Development Facilitation Team (DFT) – Review Comments

Project No: PR-2021-005714 Date: 12/06/2023 Agenda Item: #9 Zone Atlas Page: G-14

Application For: SD-2023-00165-PRELIMINARY/FINAL PLAT (DHO)

Project Name: Lot 1-A Monkbridge Addition

PLAT
OF
LOTS 1-A
MONKBRIDGE ADDITION
PROJECTED SECTION 5 T10N, R3E, N.M.P.M.
WITHIN THE TOWN OF ALBUQUERQUE GRANT
ALBUQUERQUE, BERNALILLO COUNTY, NEW MEXICO
JUNE 2021

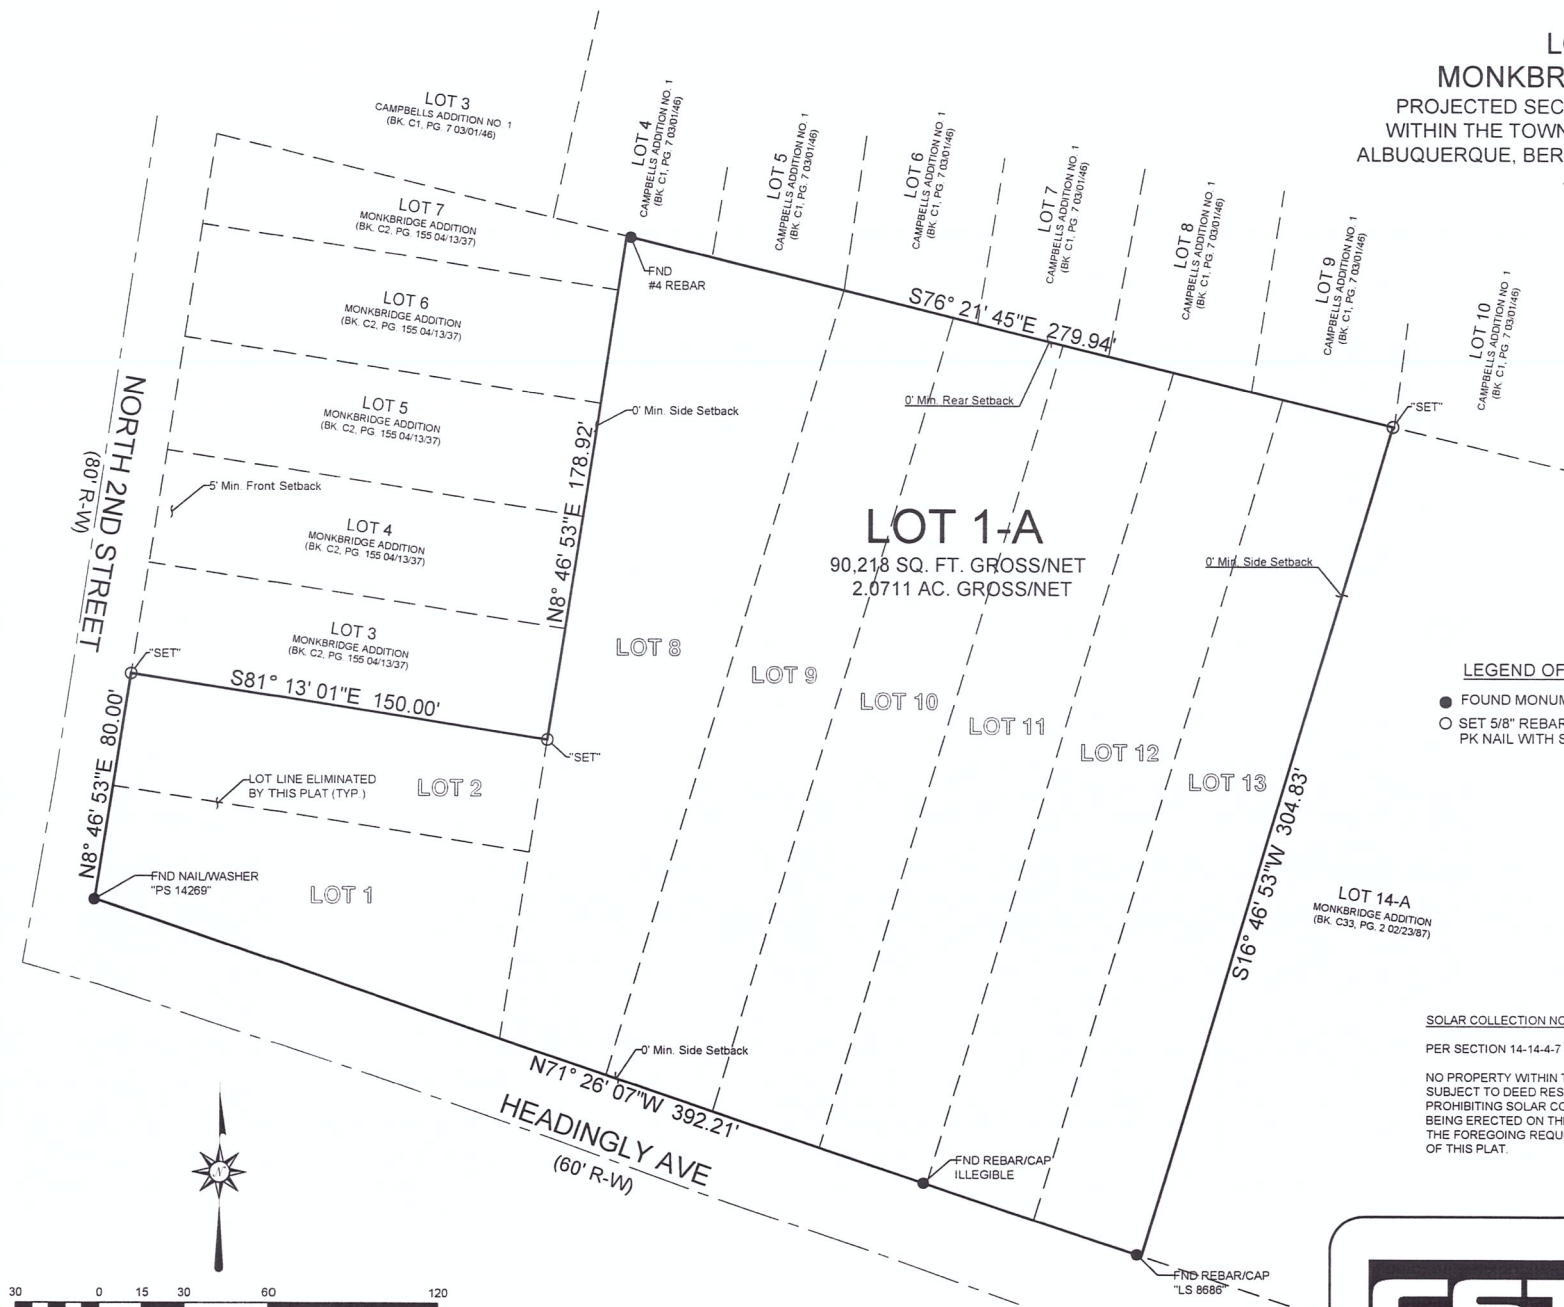
1. Previous comments still apply – no new submittal showing the note has been added.
 - a. Preliminary plat:
 - i. Add the following note to the plat.
 1. “Existing public water and/or sanitary sewer infrastructure may not be constructed or sized to adequately serve potential future development. Improvement or upsizing of existing public infrastructure may be required as a condition of future development approval.”
 - ii. No issues with the proposed lot consolidation.
 1. Availability Letter 230411 has been issued and identifies the conditions for service for the proposed site plan. Fire flow cannot be met with existing conditions and line upsizing is required. Construction or infrastructure list with financial guarantee to install new fire hydrant and installation of new 8” main for the proposed development will be required.

- DXF approval from AGIS must be obtained. The application number must be added to the Plat.

- Once/if the plat is approved by the DHO, the date of DHO approval must be added to the plat prior to final sign-off of the plat.

SITE PLAN OF
LOTS 1-A
MONKBRIDGE ADDITION
 PROJECTED SECTION 5 T10N, R3E, N.M.P.M.
 WITHIN THE TOWN OF ALBUQUERQUE GRANT
 ALBUQUERQUE, BERNALILLO COUNTY, NEW MEXICO
 JUNE 2021

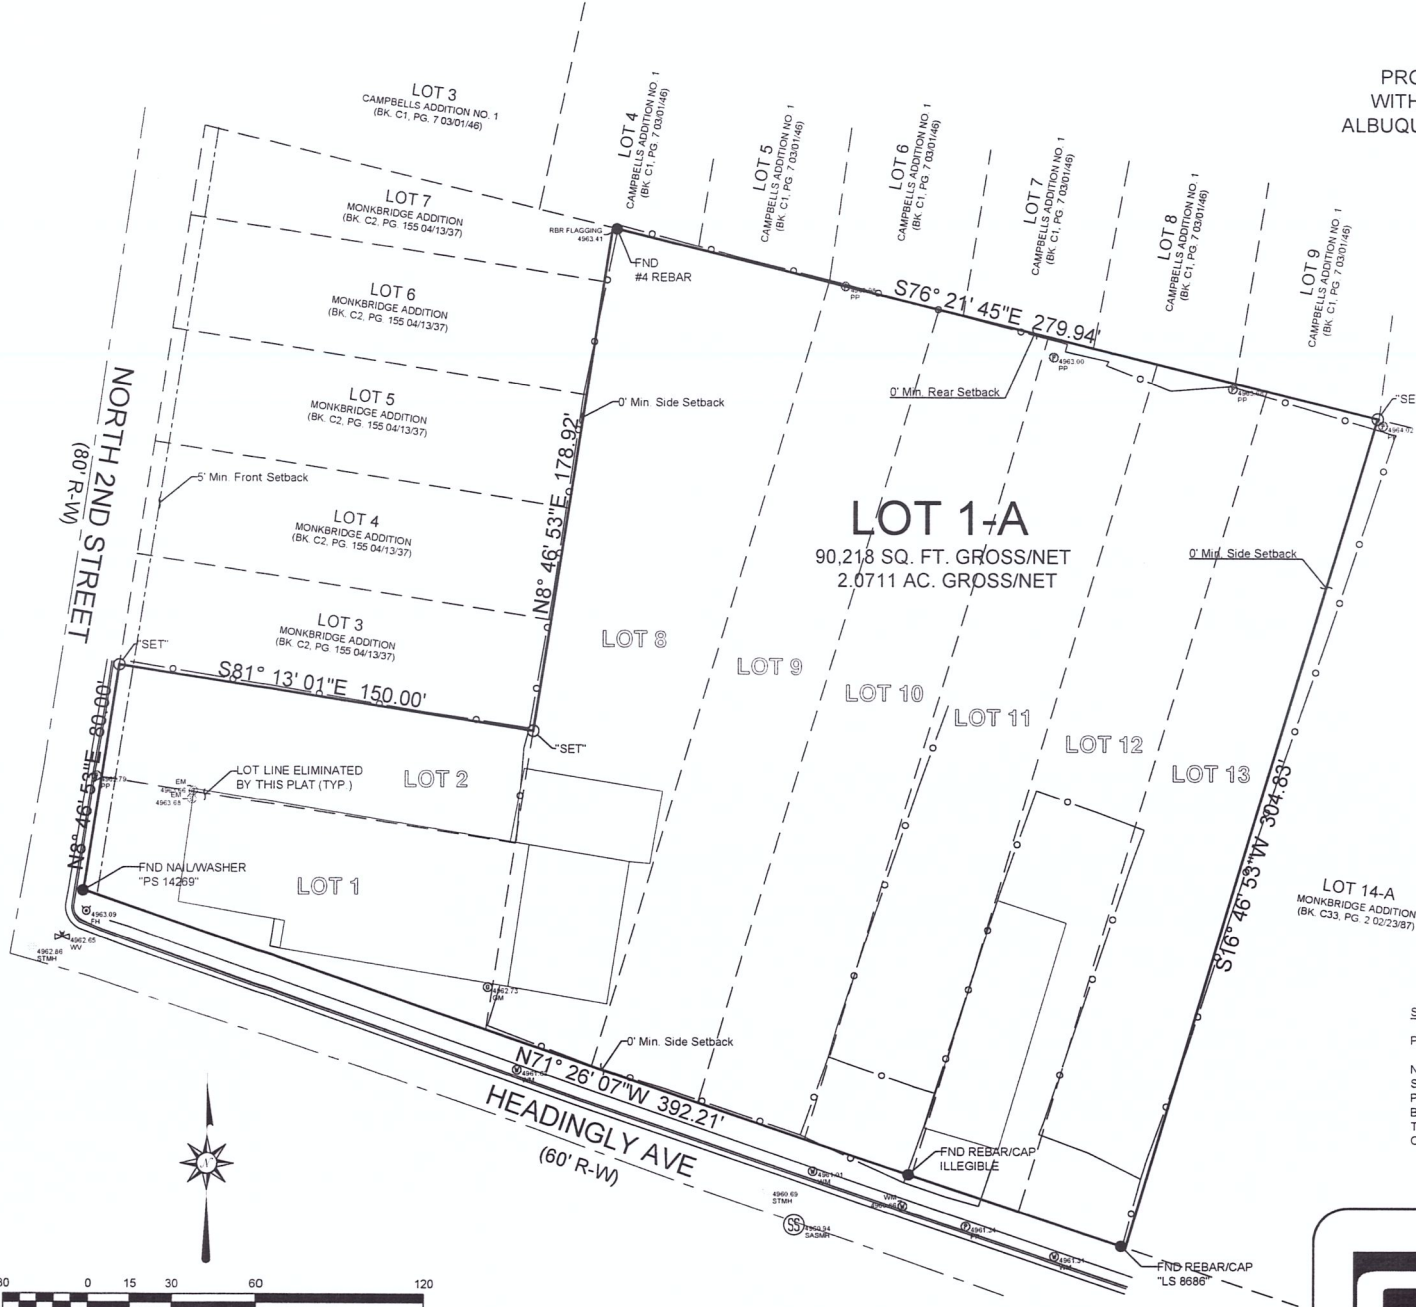
1. Show existing sidewalk widths and distances from curb to right-of-way. Right-of-way dedication may be required on Headingly or 2nd Street. Your sidewalk exhibit does not show widths or distance to from curb or right-of-way.
2. 2nd Street is a Principal Arterial and requires a 6-foot sidewalk with a 5-6 foot landscape buffer along the frontage. Provide an exhibit showing proposed sidewalk, and provide additional right-of-way width for the bus stop to allow for a future bus shelter. There is a proposed bike lane along 2nd Street, please provide a cross section to show that it will fit in the existing right-of-way or right-of-way dedication may be required
3. Headingly is a Local road and requires a 5-foot wide sidewalk with 4-6 foot landscape buffer.

- ***Please confirm ROW development and any changes. Include compliance detail for section 7 of the DPM Table 7.2.29 regarding Sidewalk width requirements and its landscape buffer.**
 - *Verification of standards per Transportation****
 - Headingly Ave NW is a local street, requiring a 5-ft sidewalk and 5-6-ft landscape buffer
 - 2nd Street NW is a minor arterial, requiring a 6-ft. sidewalk and 5-6-ft landscape buffer.
